Alterations & first floor extension, providing a reduced garden room on the ground floor, together with conversion of garage to a gym & 2 new bedrooms, study & bathroom to first floor. Removal of existing pitched roof & replace with lower mono pitched roof

Sandgate House South Strand East Preston Littlehampton

Thank you for your internet representation made on 7th August 2012 which has been recorded as **an objection** with the comments as follows:

1207 SK23
Sandgate House, East Preston
First Floor As Proposed
June 2012
scale: 1:100

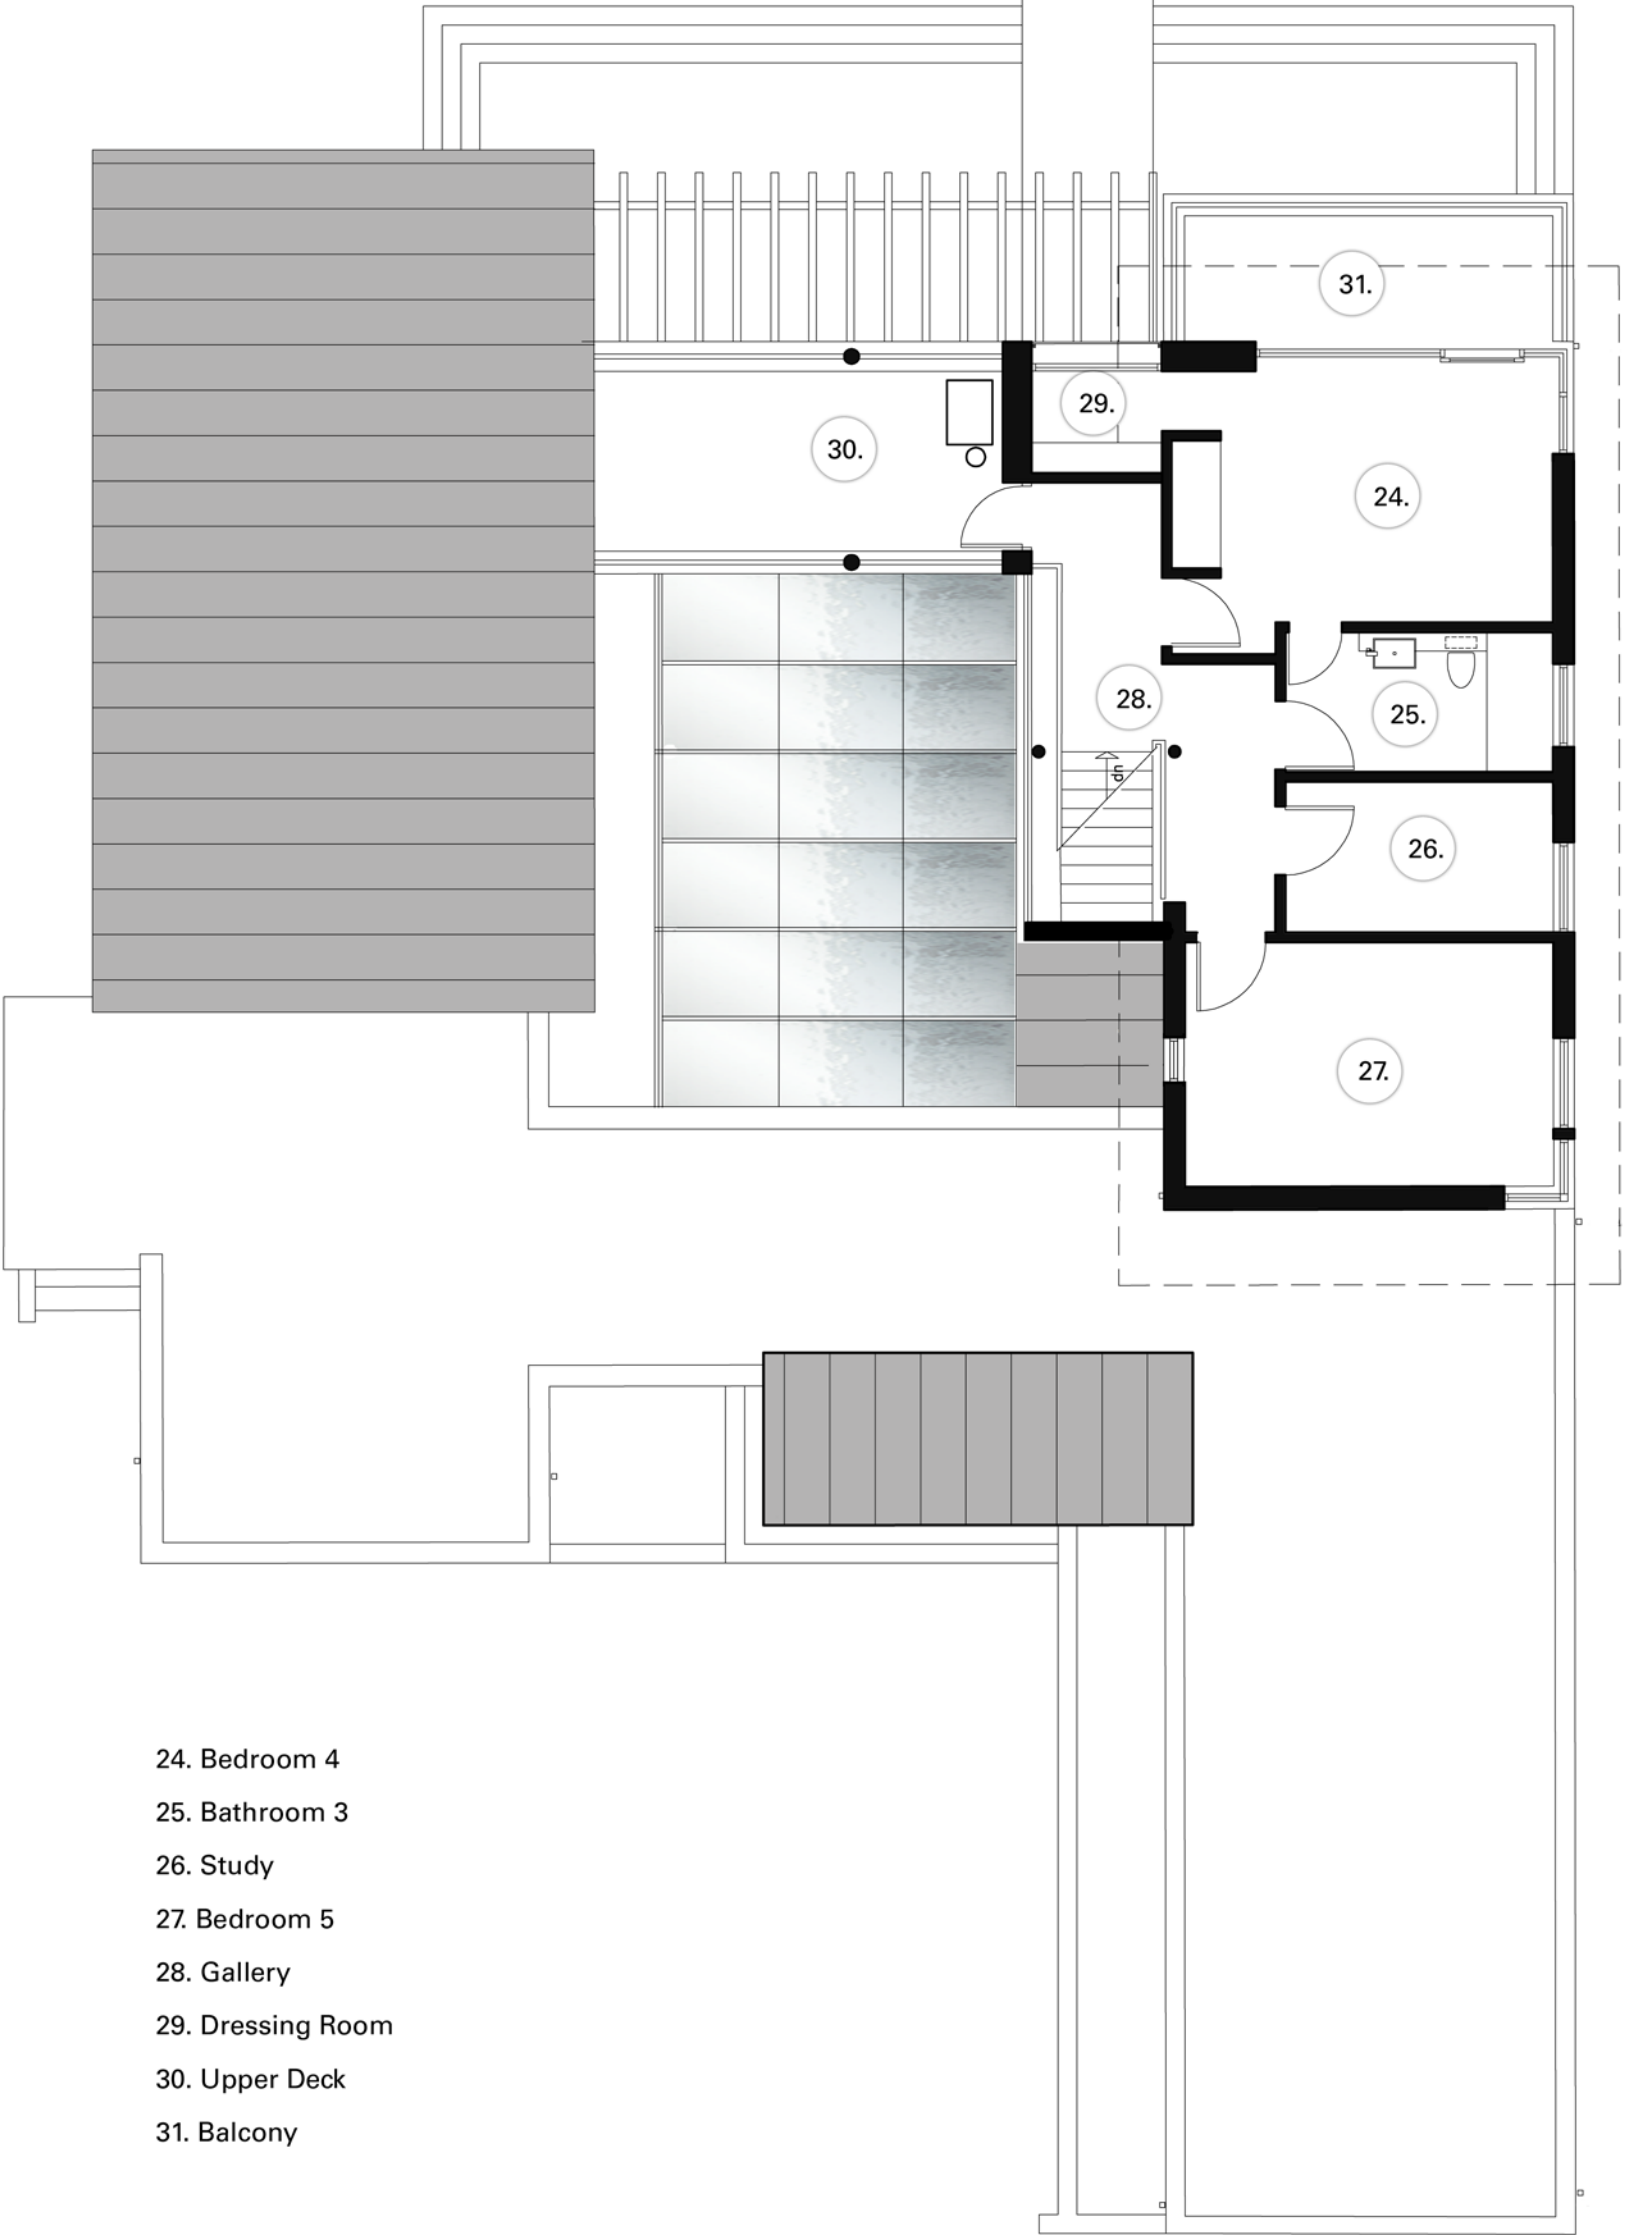
The new balcony on the proposed building would overlook the gardens of neighbouring properties, producing an unacceptable adverse effect on them. □

1207 SK26
 Sandgate House, East Preston
 Elevations As Proposed - sheet 2
 June 2012
 scale: 1:100

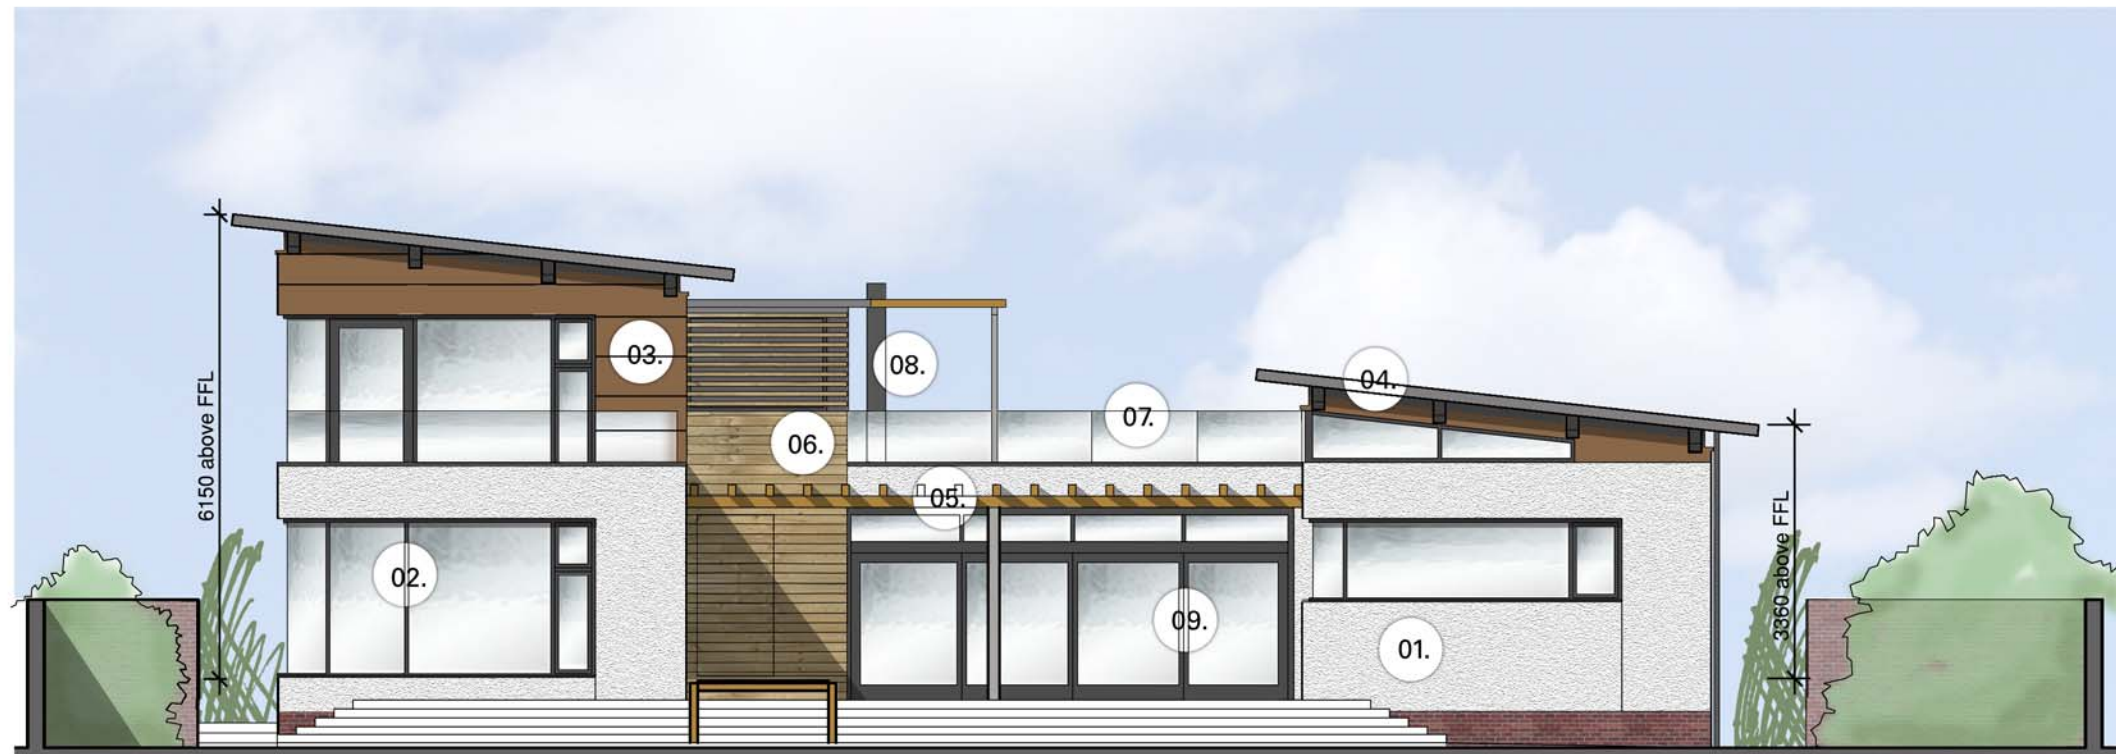
The proposed design for the rebuilt house, with flat roofs and large metal framed windows, is incompatible with the design and materials of the adjoining buildings. The rebuilt house would therefore stand out like a sore thumb among its neighbours, in a position where many people are bound to see it. □
